From: Philip Goacher Associates [REDACTED]
Sent: 18 February 2022 10:17
To: Nicola Moore
Cc: Kate Bovey
Subject: Re: WA/15/22/PL and WA/16/22/L - 22028 Walberton Park The Street Walberton BN18 0PJ
Attachments: 001 - Arun District Council.pdf; 22028 - 001A - Walberton Park, The Street, Walberton.pdf

Application reference: WA/15/22/PL and WA/16/22/L.

Project No: 22028
Drawing No: 001
Revision: A

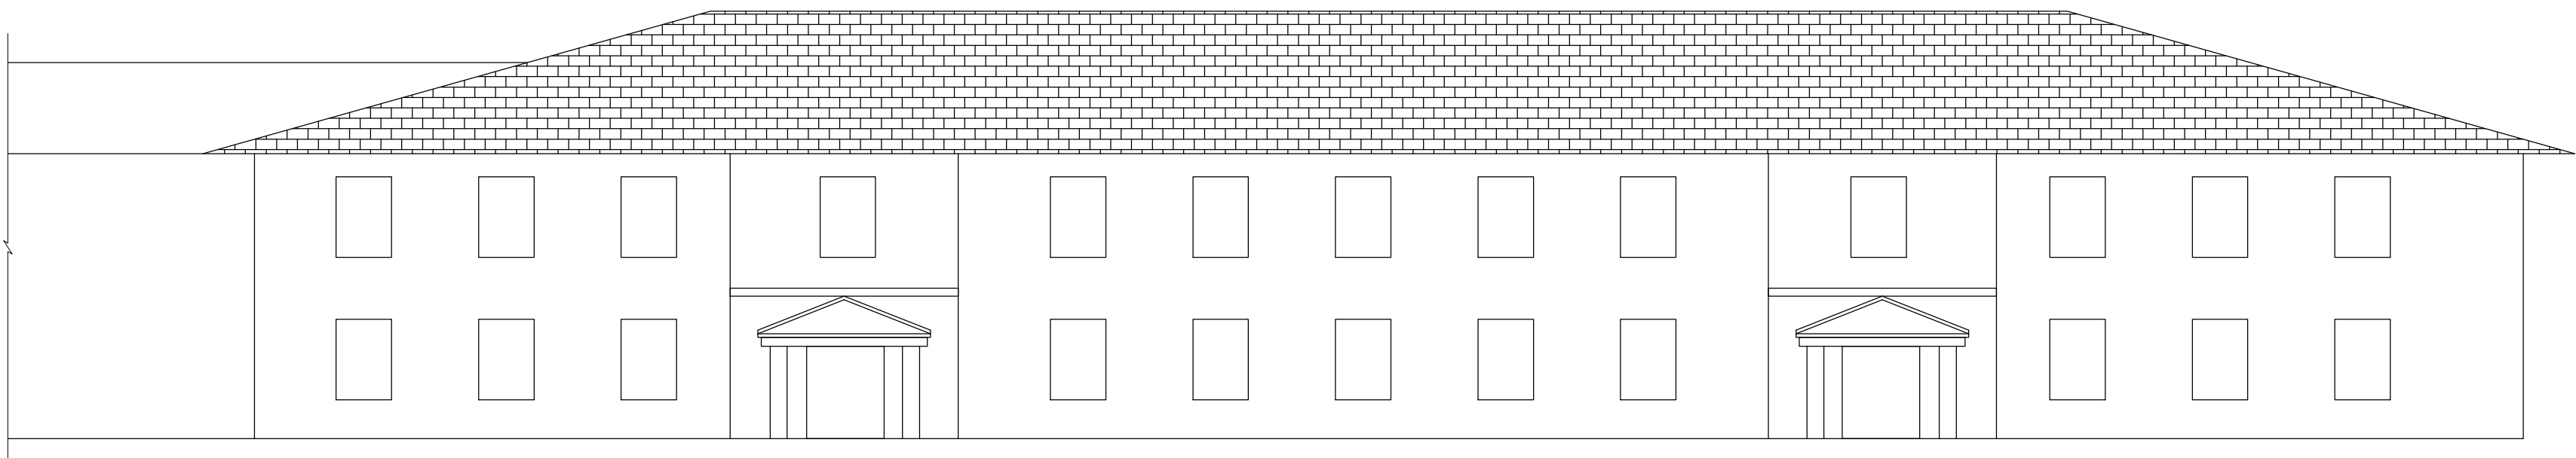
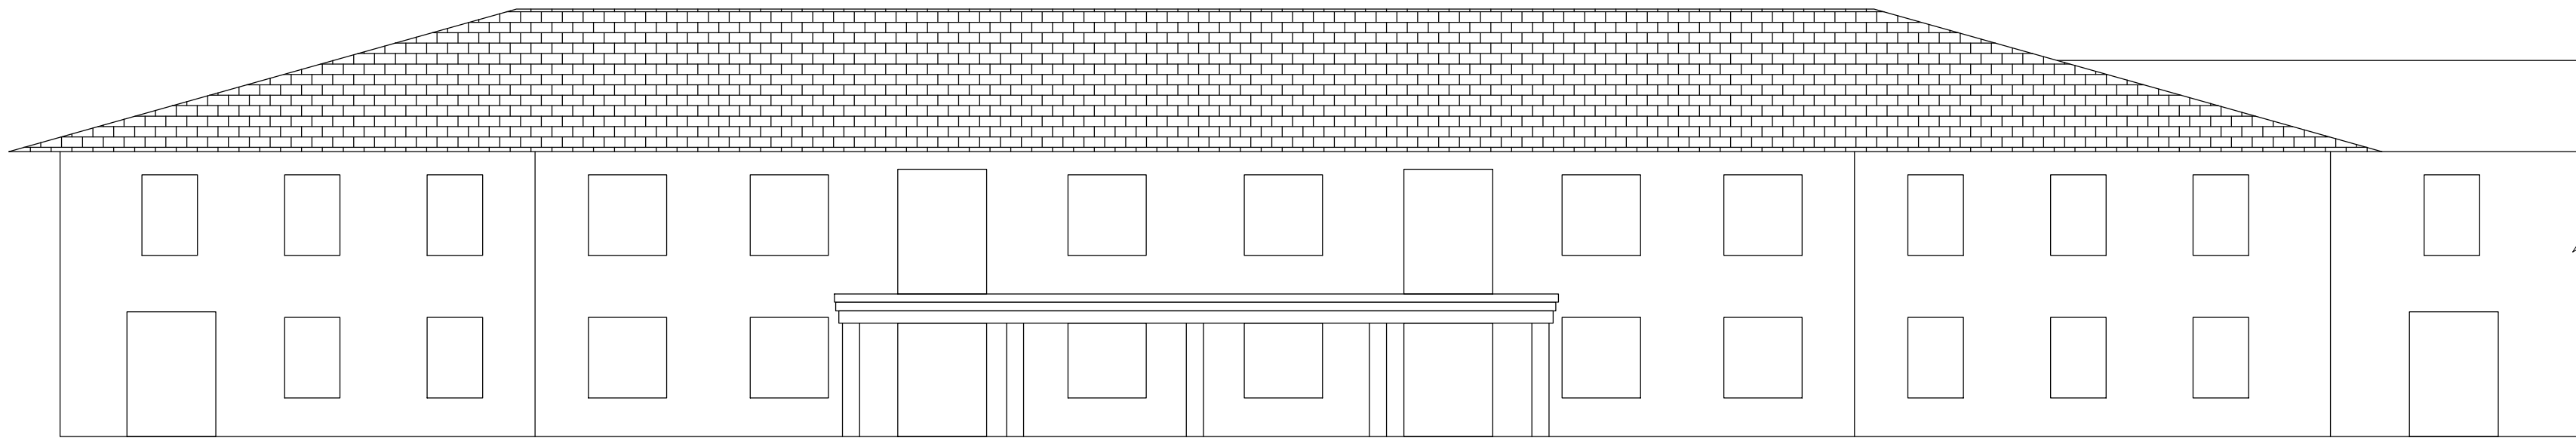
The Method statement is okay. However, I have noticed that the scale on the Existing & Proposed Elevations is 1:100, but the scale bar is 1:50. Please can you amend accordingly and re submit.

Please refer to the updated drawing no. 22028 - 001A with the 1:100 scale bar added.
